Suffolk County Council (20041323)

Post-Hearing Submission for the Third Issue Specific Hearing (ISH3) into Transport and Rights of Way

Bramford to Twinstead (EN020002)

Deadline 4

Reproduced from Ordnance Survey maps by permission of Ordnance Survey on behalf of the controller of His Majesty's Stationery Office. © Crown Copyright Ordnance Survey, Licence no. 010059731

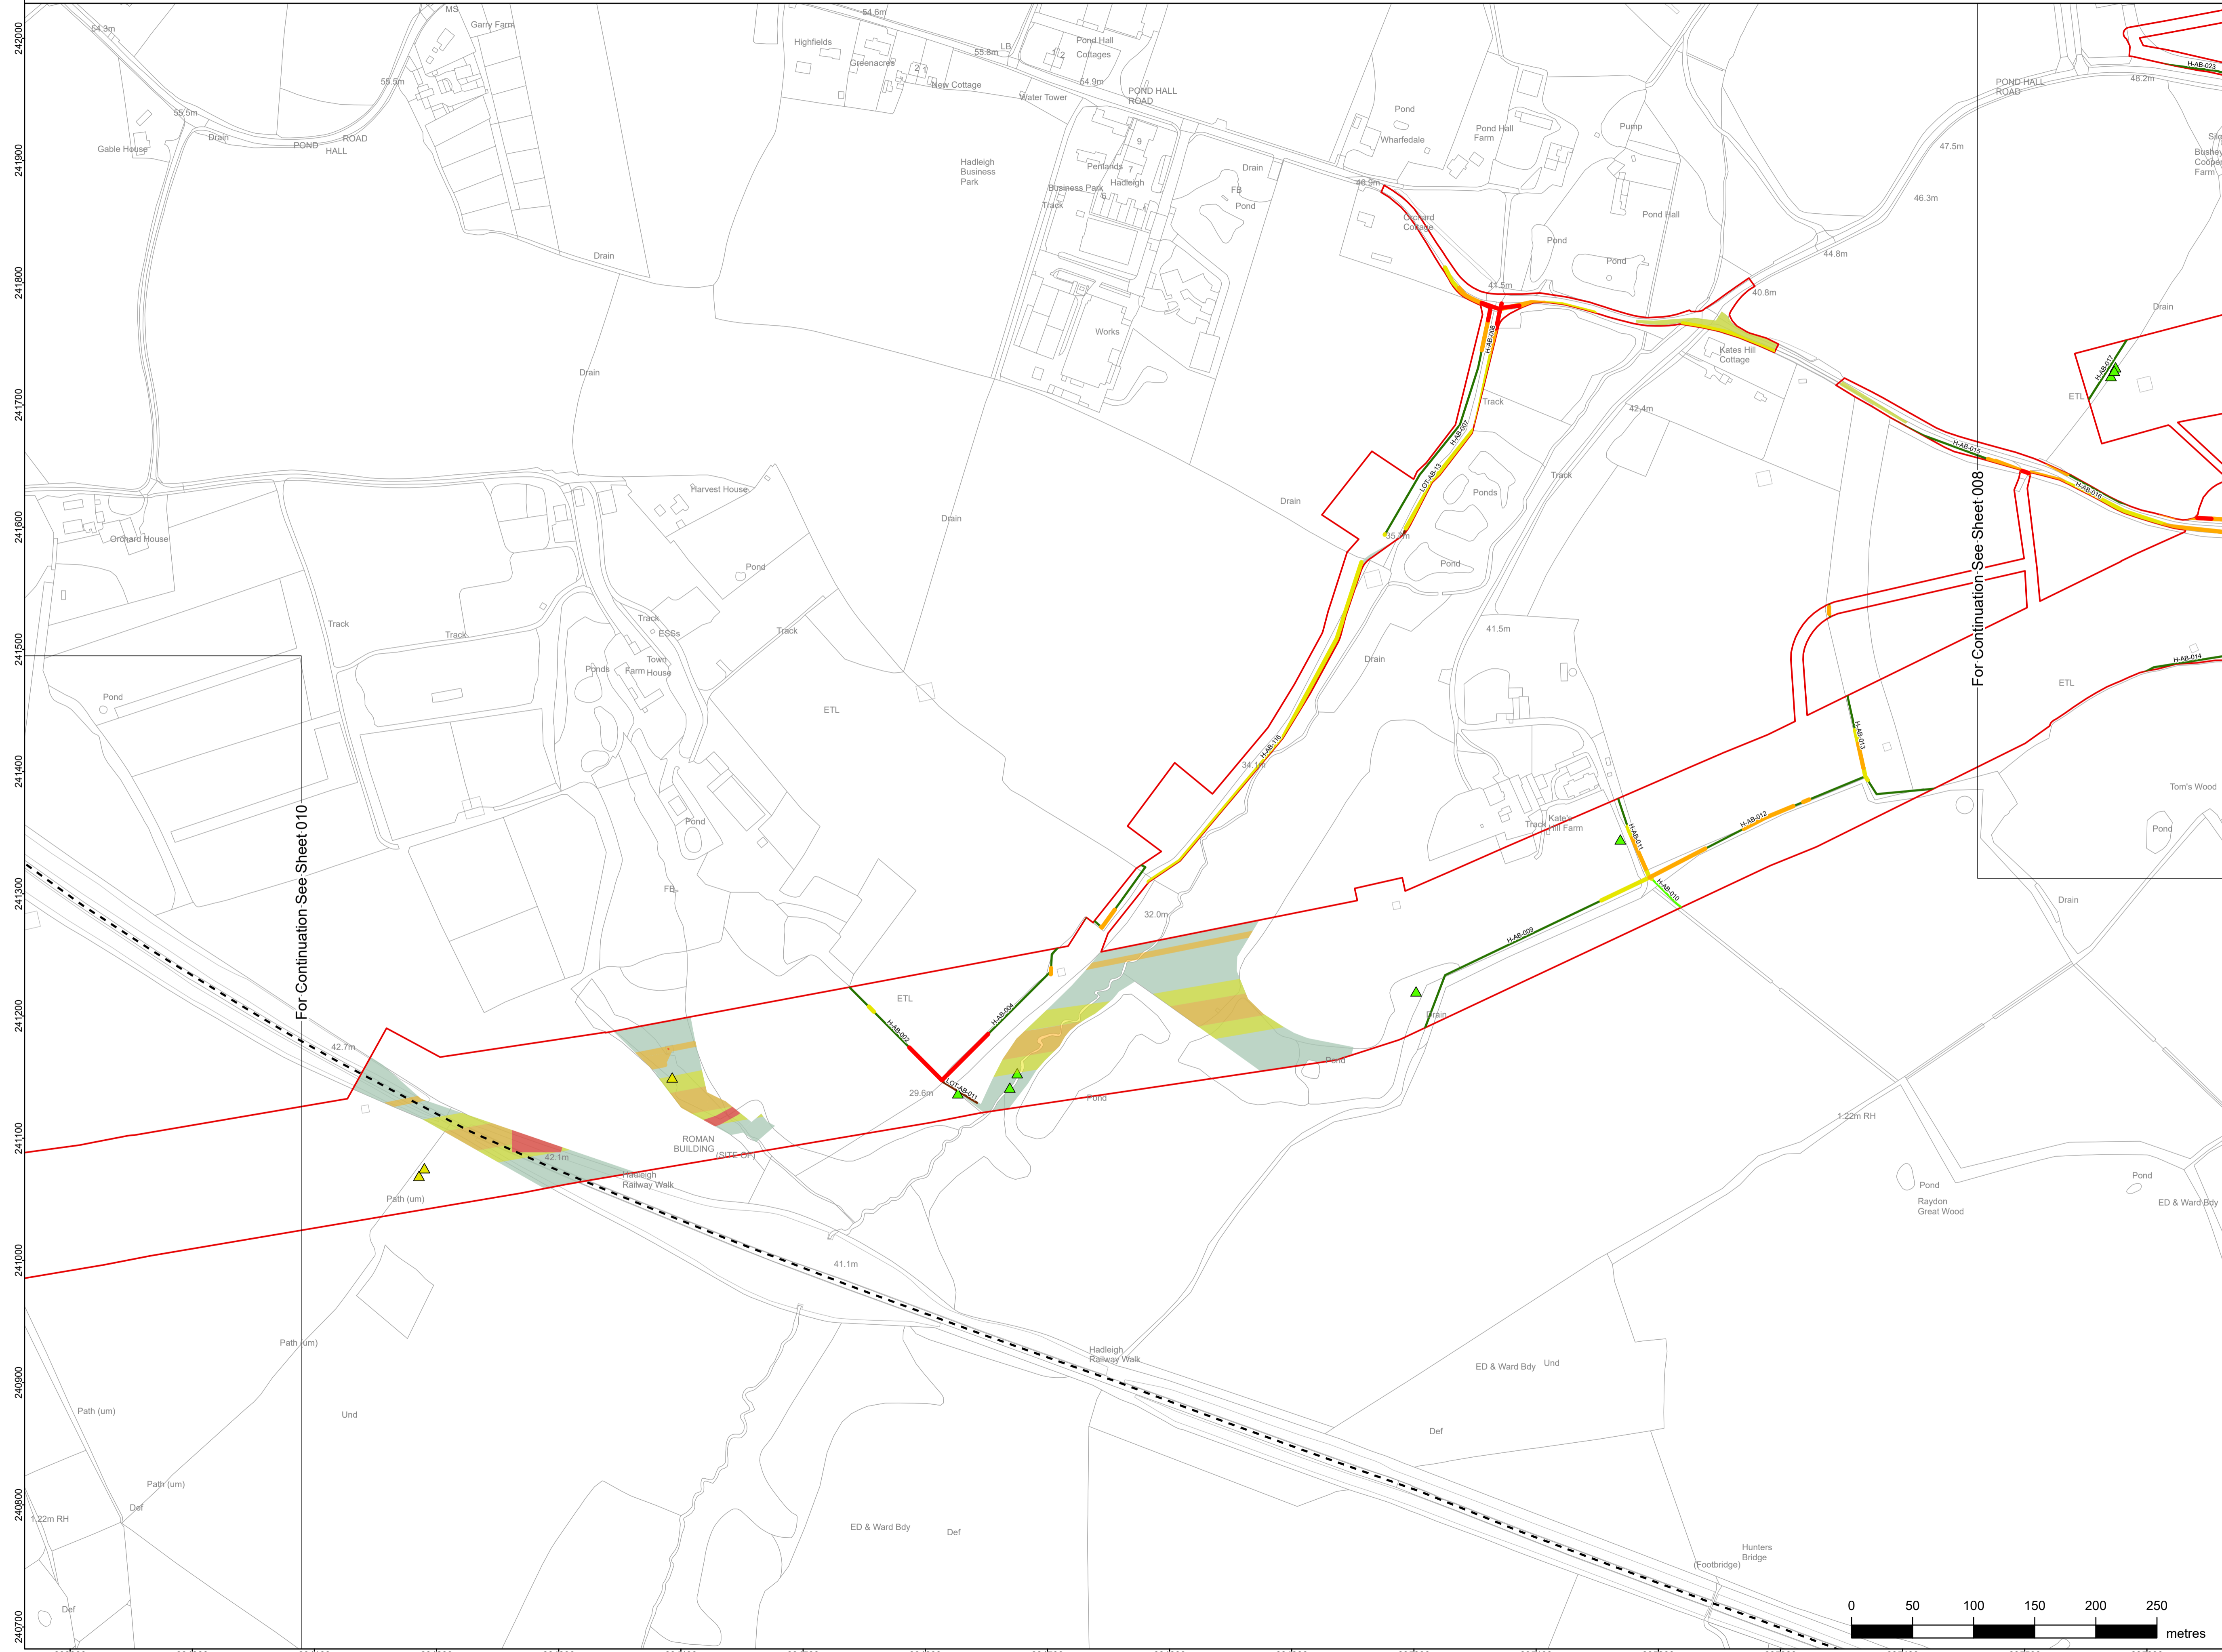
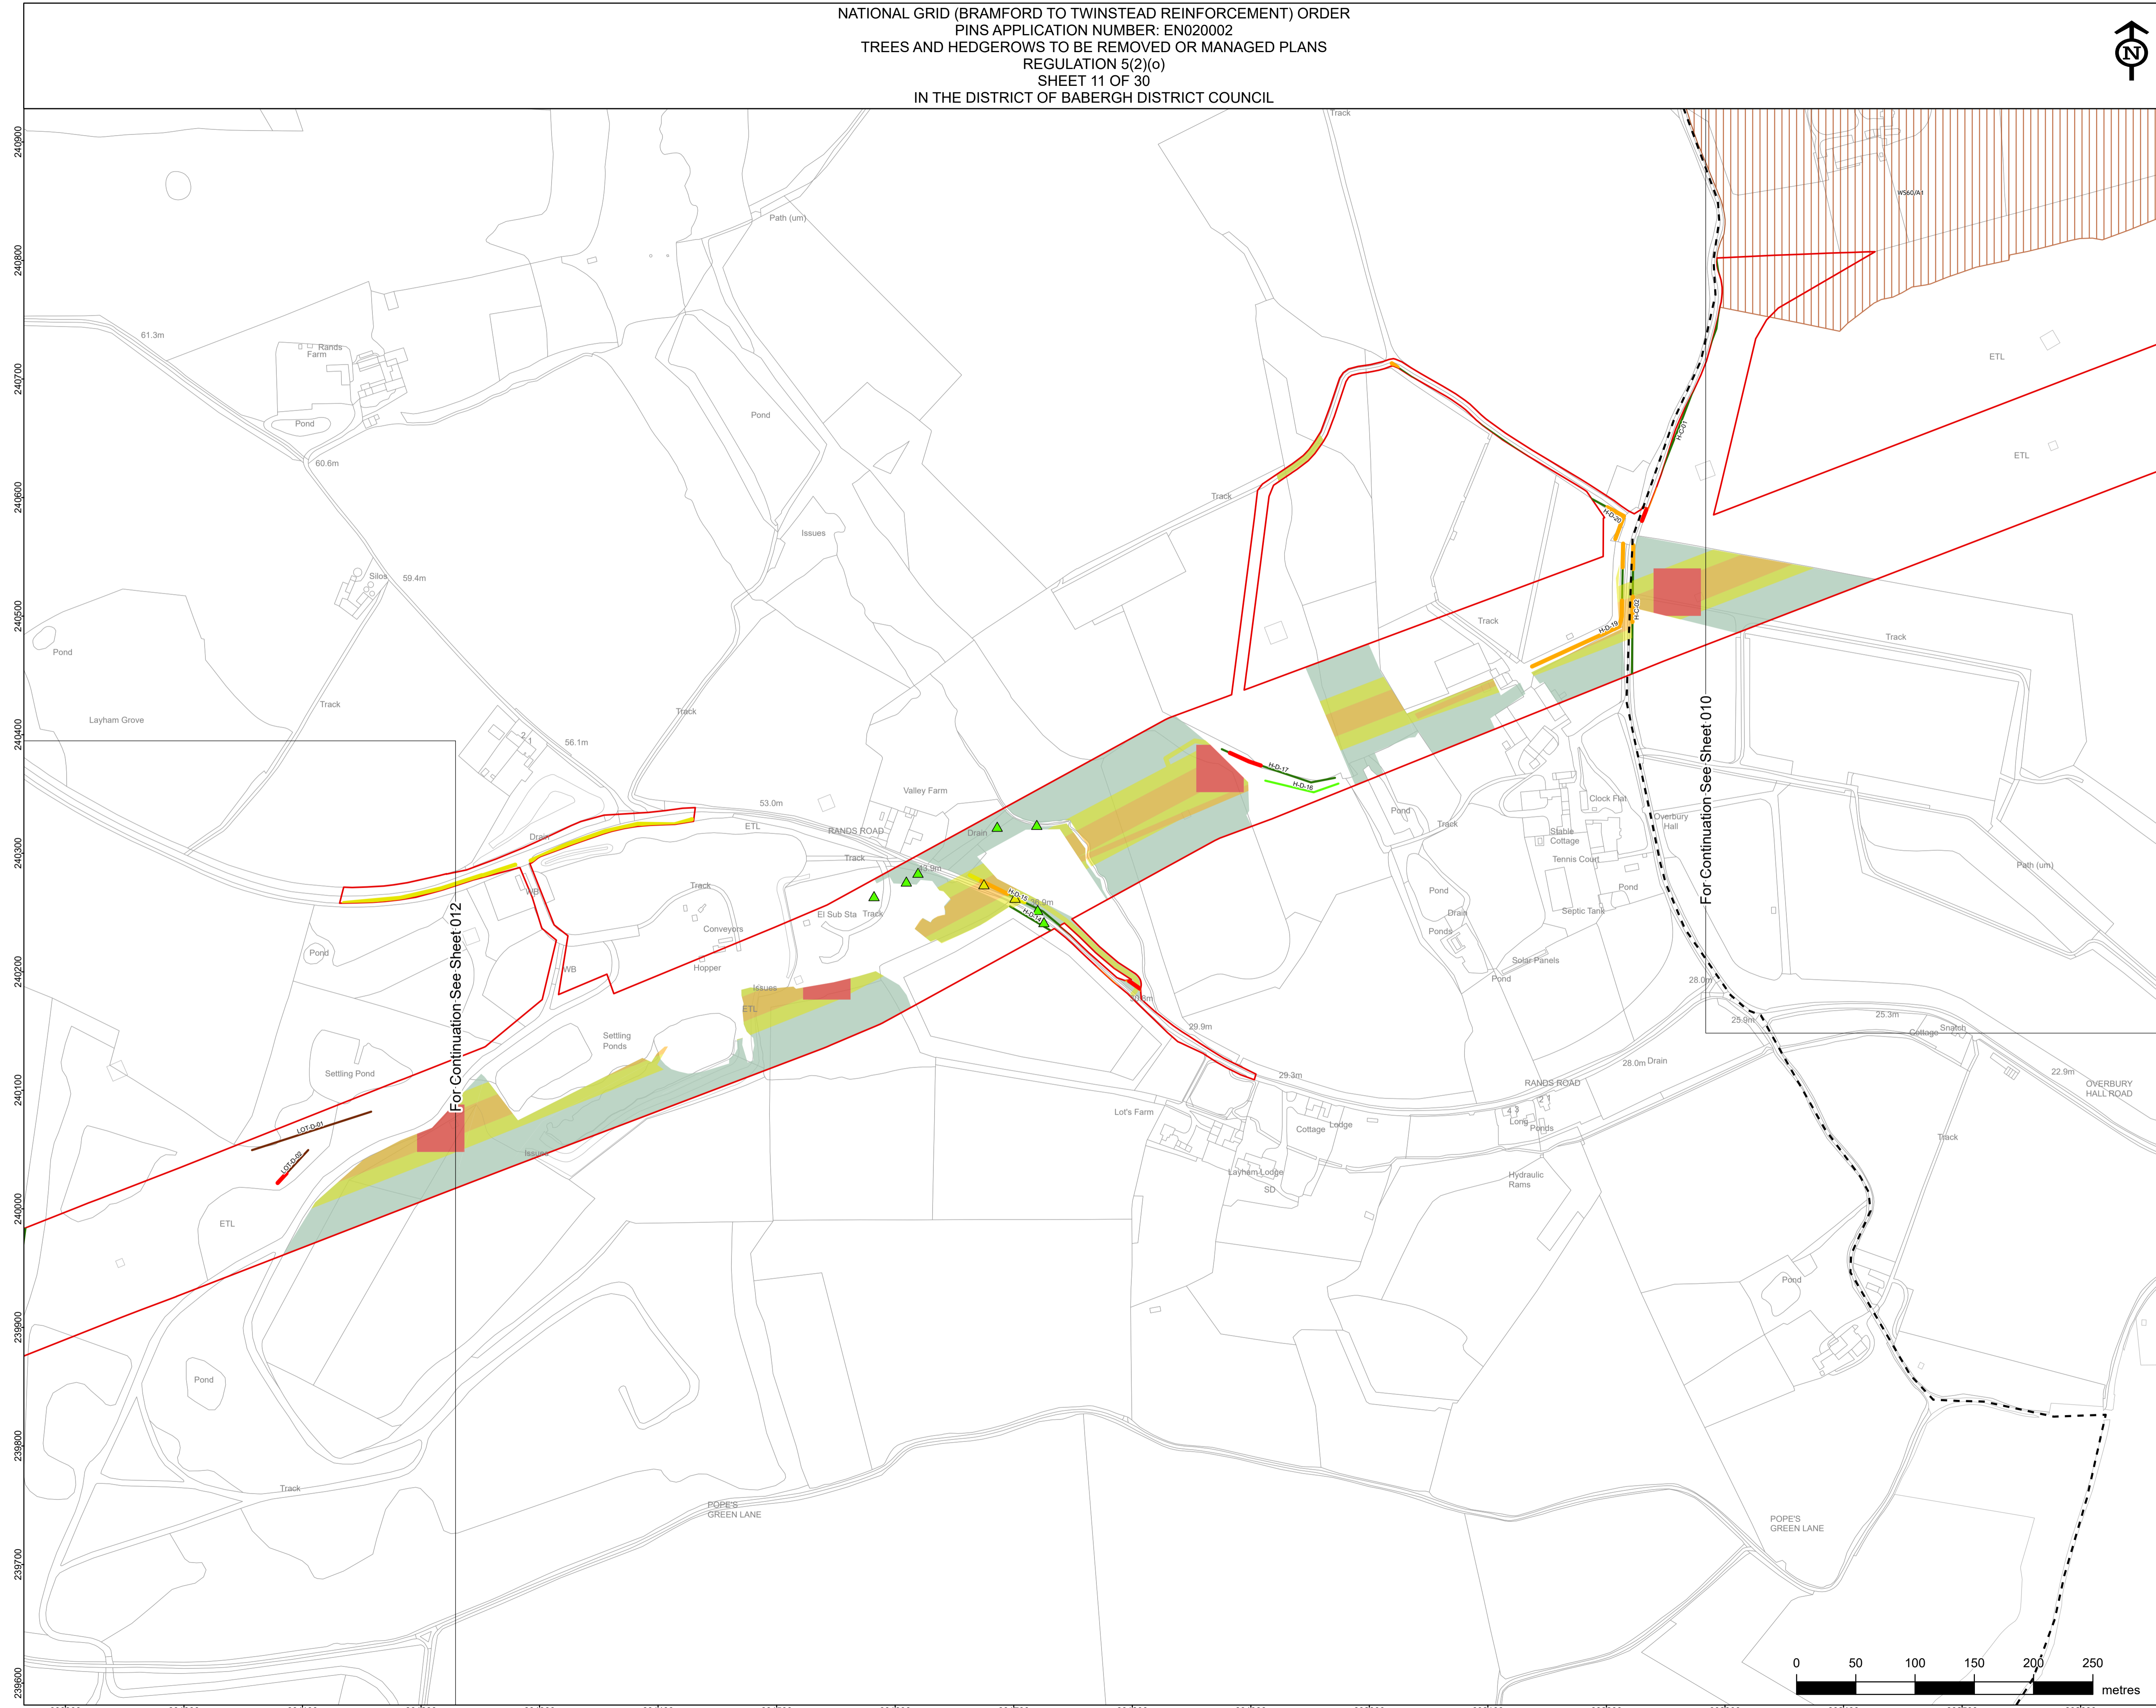
The plans provided are of such large scale to make it difficult to measure the areas proposed for visibility splays.

An example from Church Hill, Burstall in our option shows the issues. The road is currently derestricted but will be subject to a temporary 30mph limit during construction. Even allowing for such a temporary speed limit having good compliance, this will still require a 2.4m x 90m visibility splay as required as by the Suffolk Design Street Guide 2022 Appendix F (see Appendix 1). This would necessitate significant trimming if not removal of trees and hedges. SCC also notes that pollarding / raising the crown of trees whilst practical for individual trees would not resolve the visibility issues if there were a line of trees.

A second example is the permanent access D-DAP2 off Millwood Road, Polstead. The road is derestricted (60mph) and as the temporary speed limit will be remove post construction will require a 2.4m x 215m visibility splay to conform with design standards in the operational phase. The 'Trees and Hedgerows to be Removed or Managed Plans' sheet 12 only shows the hedges to be coppiced which unless repeatedly cut (to 600mm agl) would not provide acceptable visibility. It is noted that the visibility for D-DAP4 on inside of the bend will also be poor.
